August 8, 2014

**Subject: Congress Street Convenience Store –Portland, Maine
Comment Response # 1
Response to City of Portland Comments of Jean Fraser Dated August 1, 2014**

We have received and reviewed the email review comments dated August 1, 2014 regarding the Amended Site Plan for the 2282 Congress Street Convenience Store project. We have completed plan revisions related to these comments as well as revisions based on the client's value engineering requests. For ease of reference, we have repeated the comments (*italics*) followed by our response.

**(D) SCHEDULE 'A'**  
N.T.S.

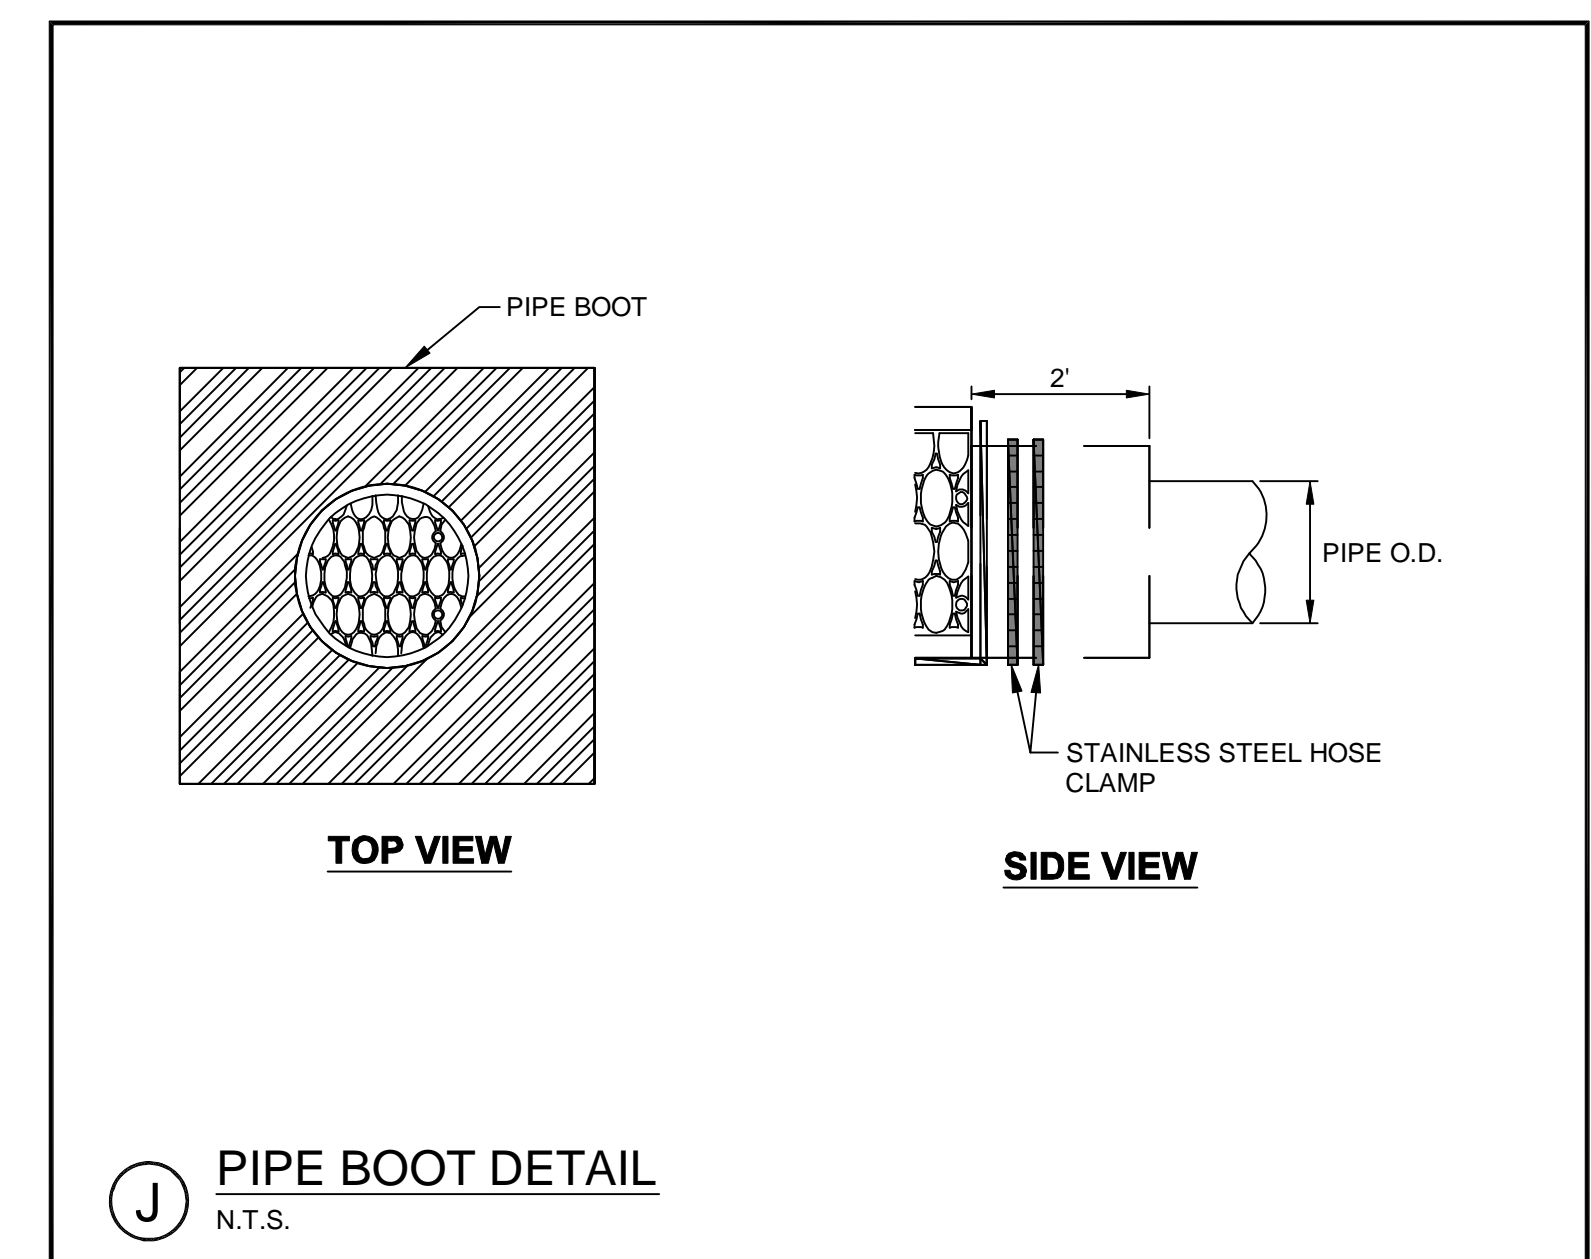
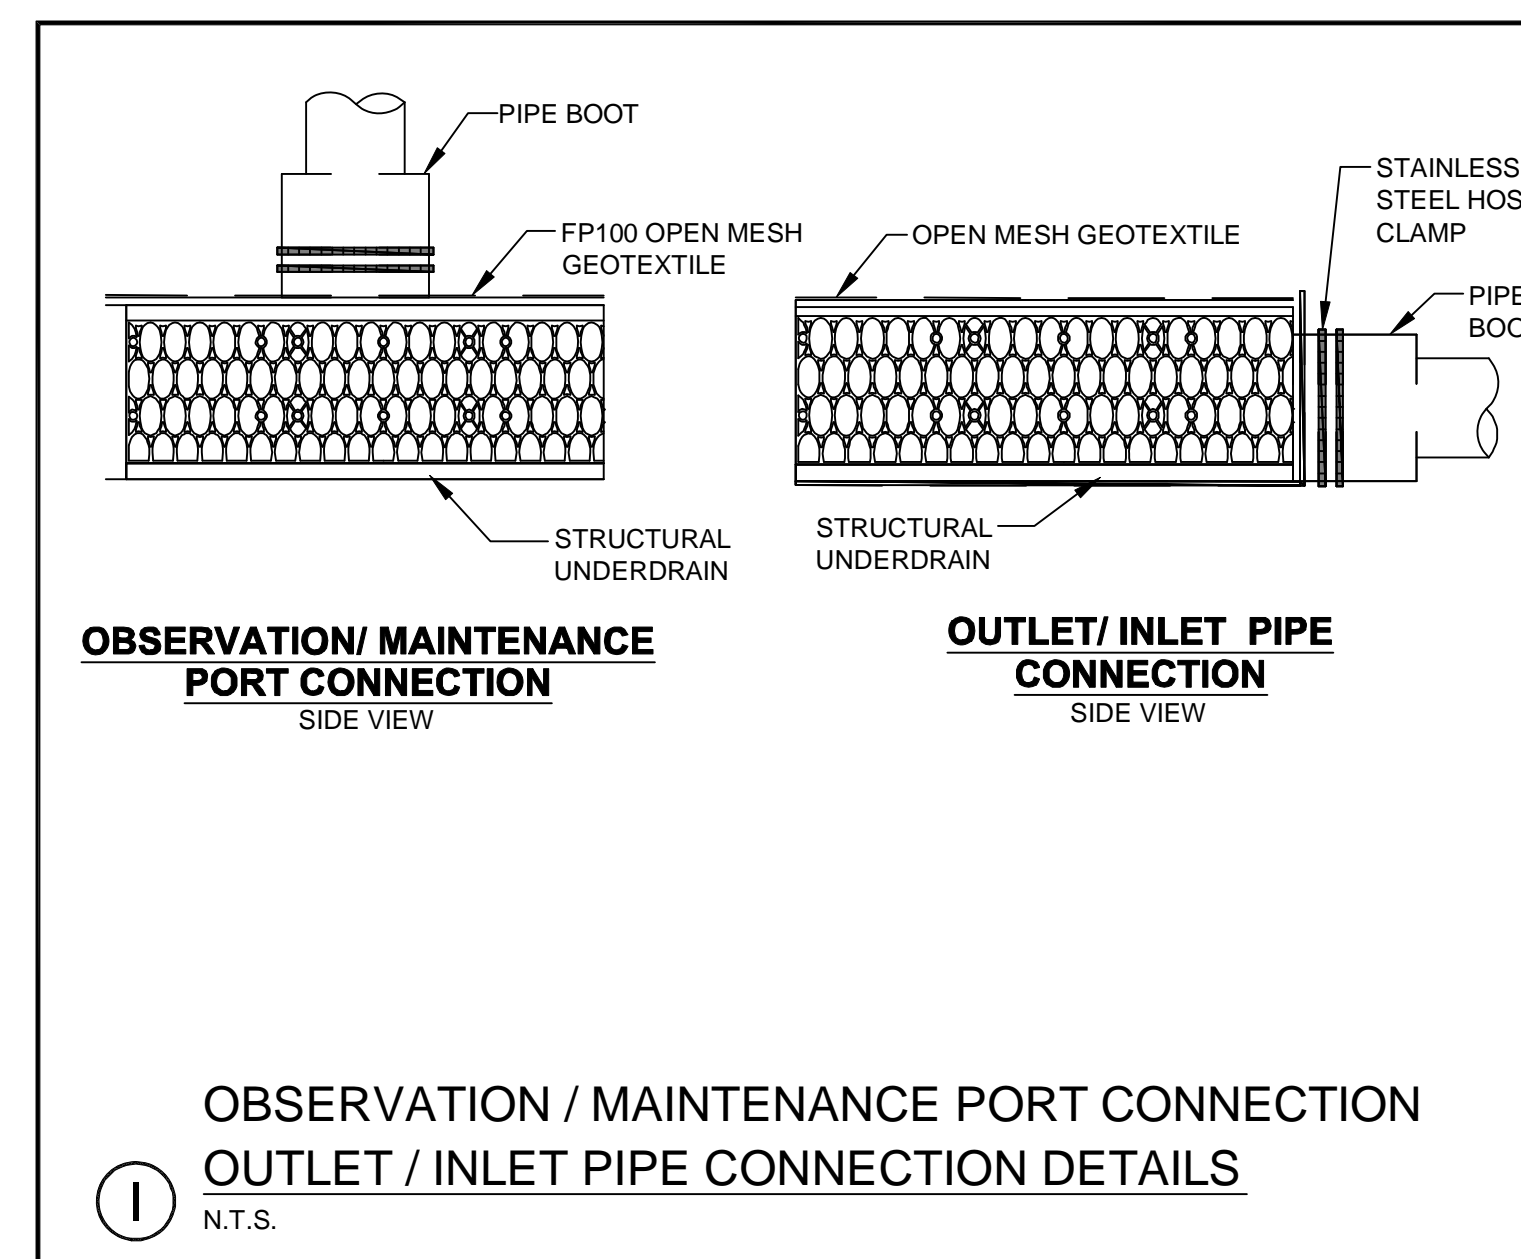
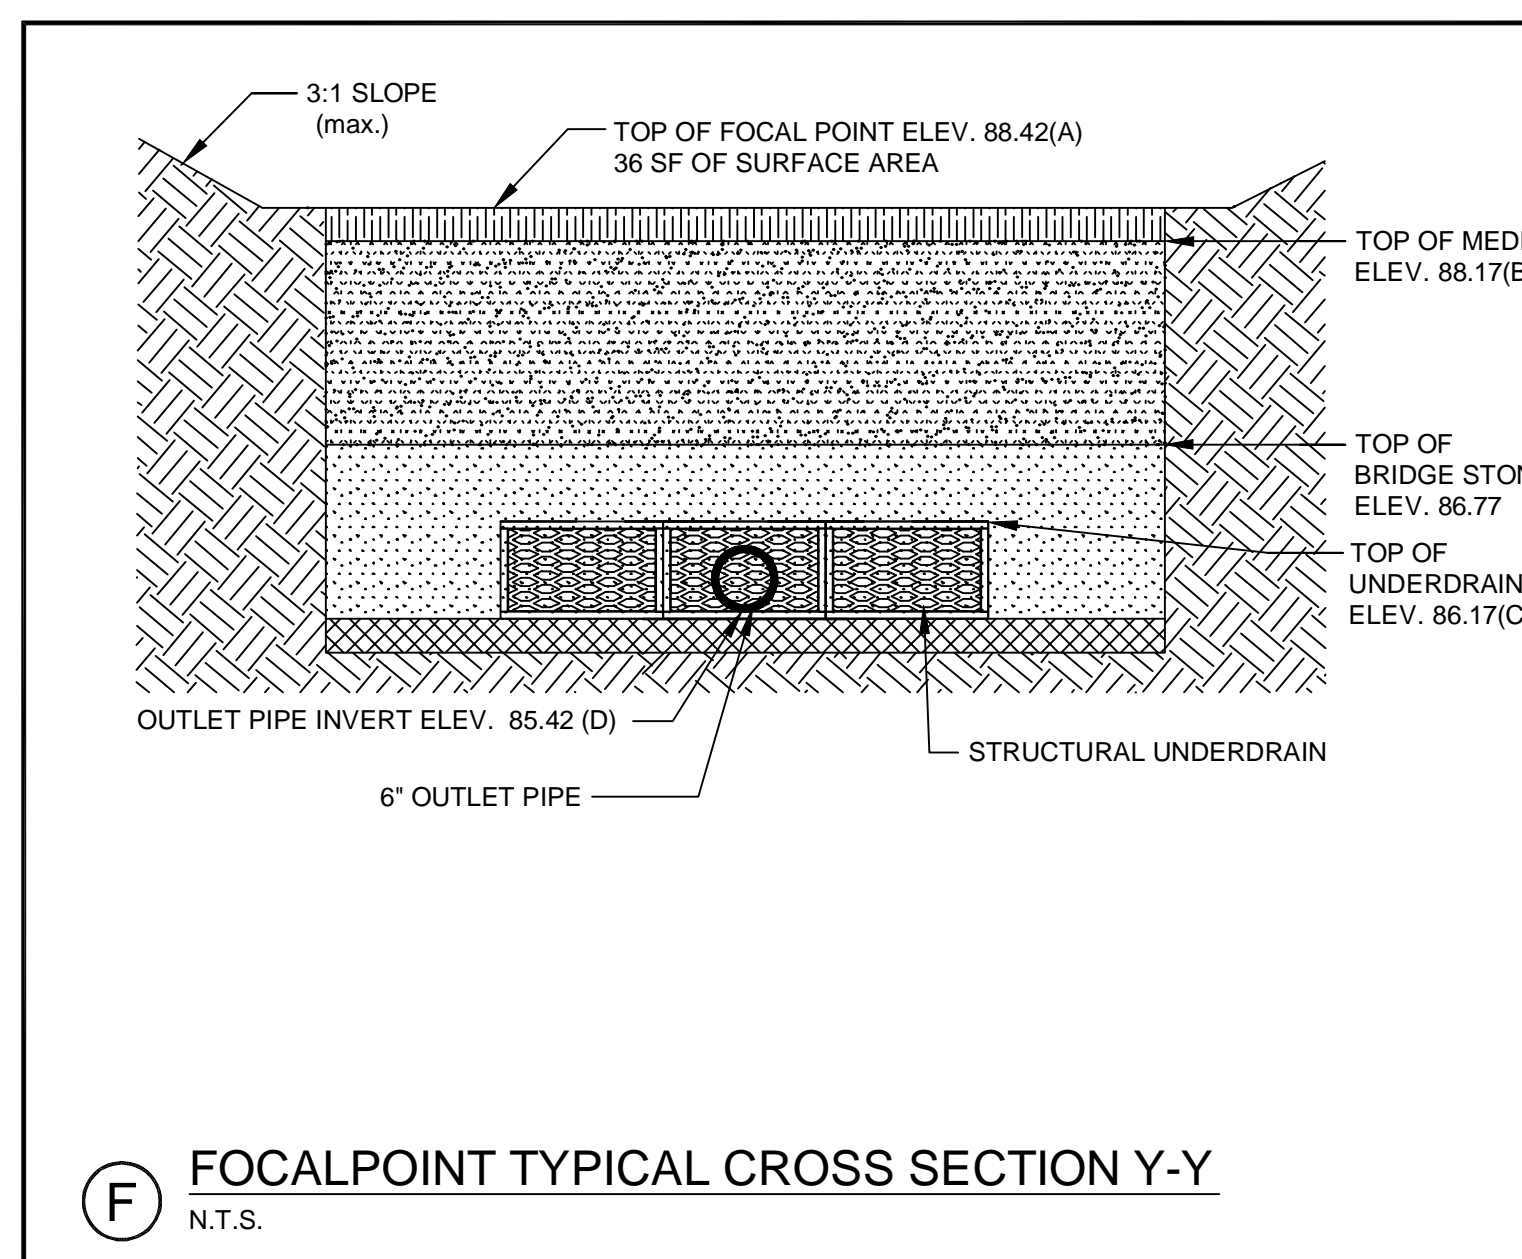
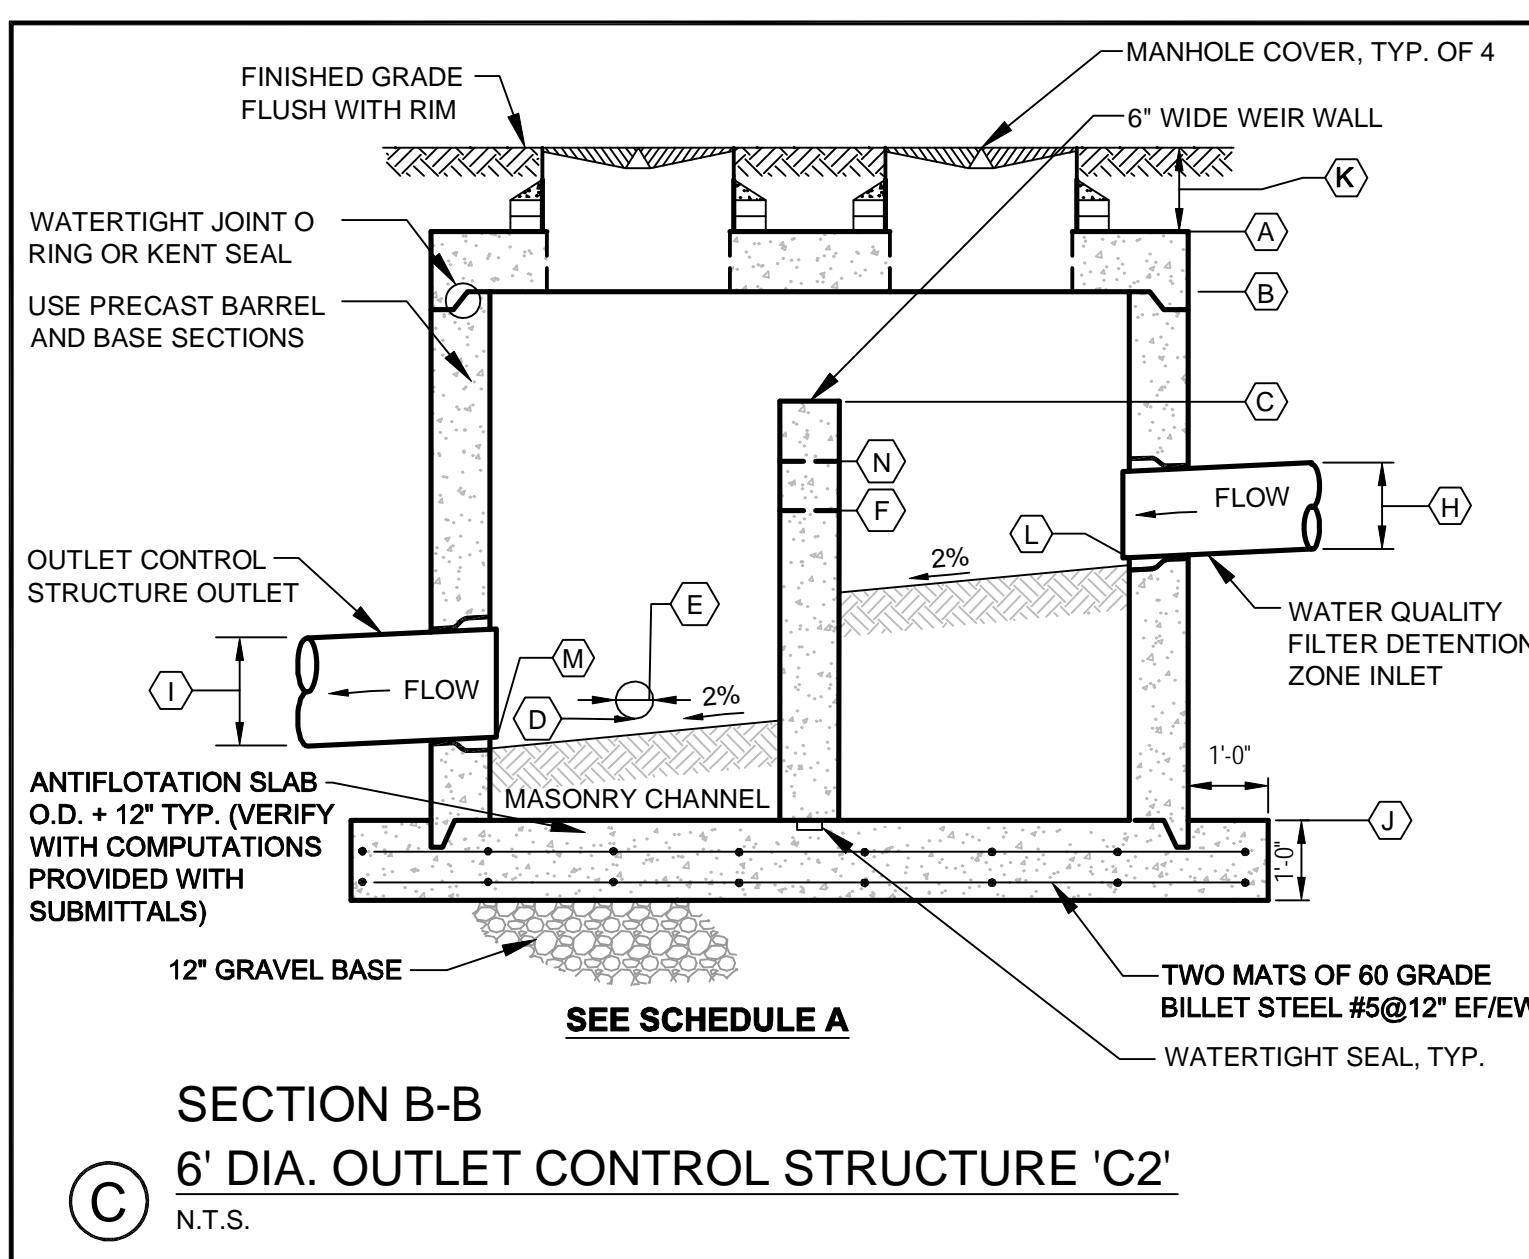
The Focal Point™ system requires a maximum water ponding depth of 0.5’ in the stormwater detention basin. This requires water release controls inside of the outlet control structure A-1 to be lowered from 89.62’ to 88.92’. The change in outlet control elevations required a re-design of the outlet control structure. In order to control the 2-year peak flow a 3” orifice was computed to control the flow at the water quality elevation of 88.92’. This resulted in the following Detention Pond “0” impacts:
